Phone: 0300 123 6780
Email: developeras@lancashire.gov.uk
Your ref: 3/2025/0989
Our ref: 3/2025/0989/HDC/KW
Date: 11 March 2026

Location: Land associated with 6 Top Row Sabden BB7 9HL
Proposal: Proposed erection of No.4 detached garage buildings following demolition of existing garages on site.
Grid Ref: 377735 437849

**Proposed Garages Layouts & Elevations for B**

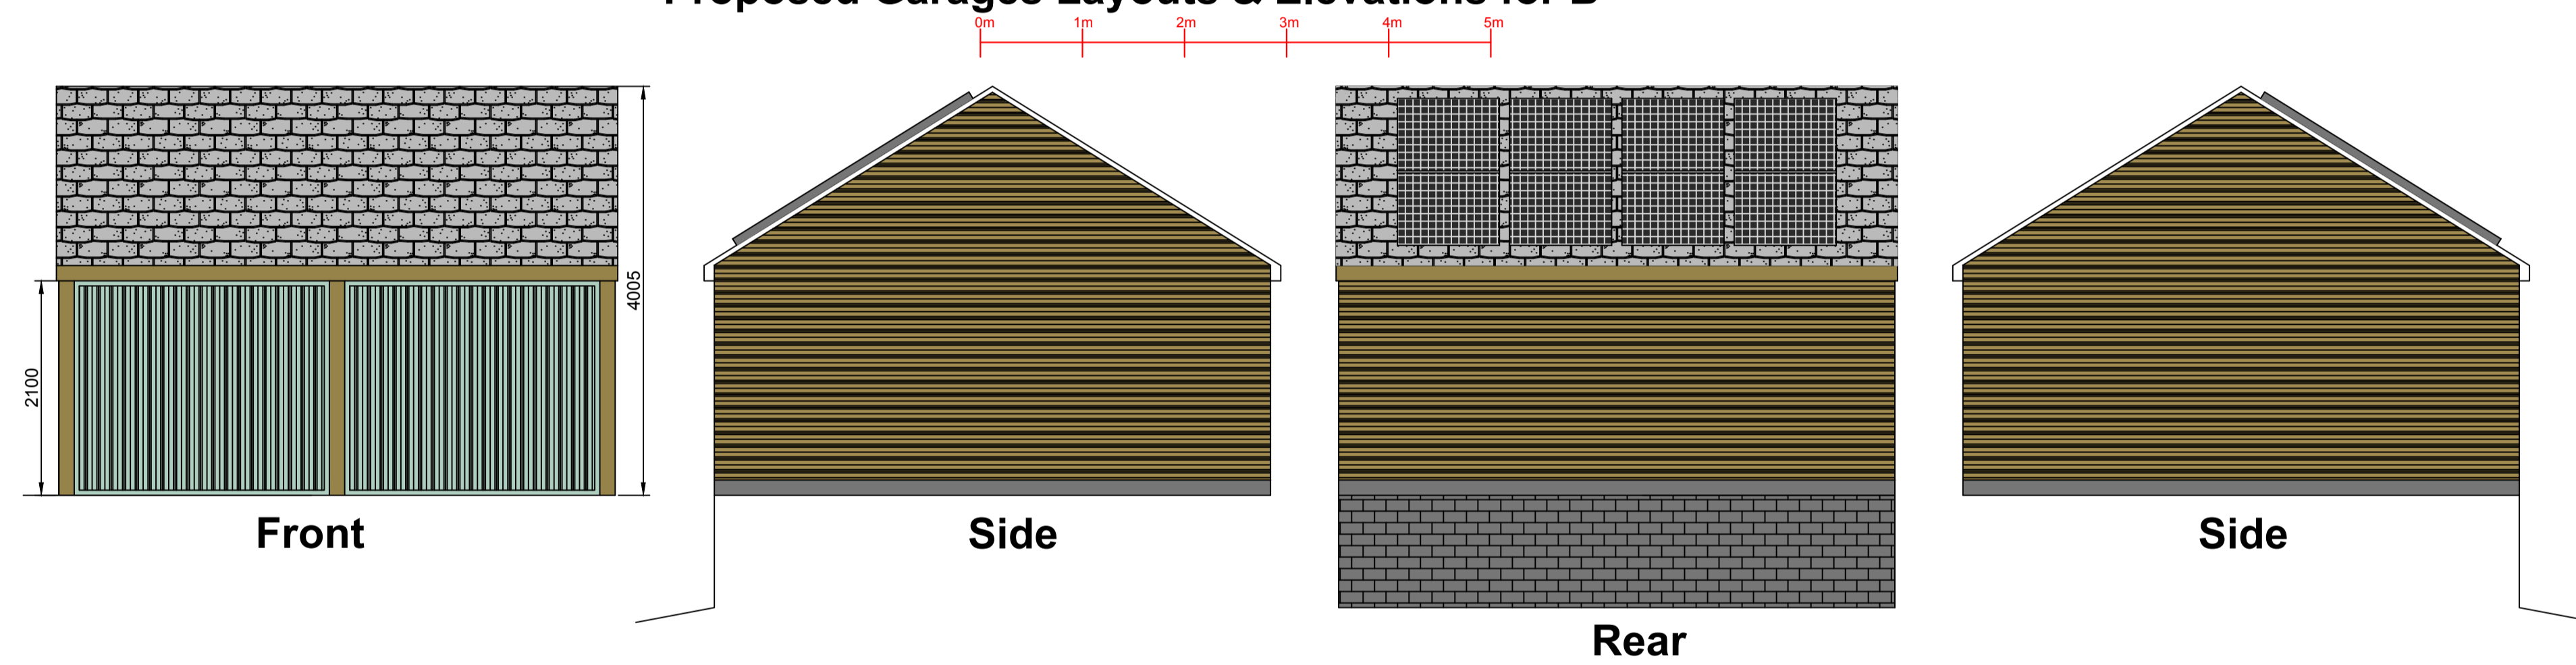
As the proposed garages are smaller than the recommended minimum internal dimension of 6 x 6m they are unlikely to provide significant parking provisions, although smaller vehicles and motorbikes could be stored with as well as for use of storage.

The LHA previous raised concerns regarding the set back distance of the garage, after discussions with the applicant, it is not possible to set the garages back 6m due to land levels. As such the LHA would request that the garages as placed no closer to the highway than the existing garages footprint. The garages should also be fitted with roller shutter type doors to ensure they do not swing outward into Top Row given there proximity to Top Row.

1. Before the garage hereby permitted is/are brought into use, the garage door shall be of roller shutter type and permanently retained in that form thereafter for the lifetime of the development. The design should be submitted prior to implementation to the Local Planning Authority to ensure it remains appropriate for the environment.
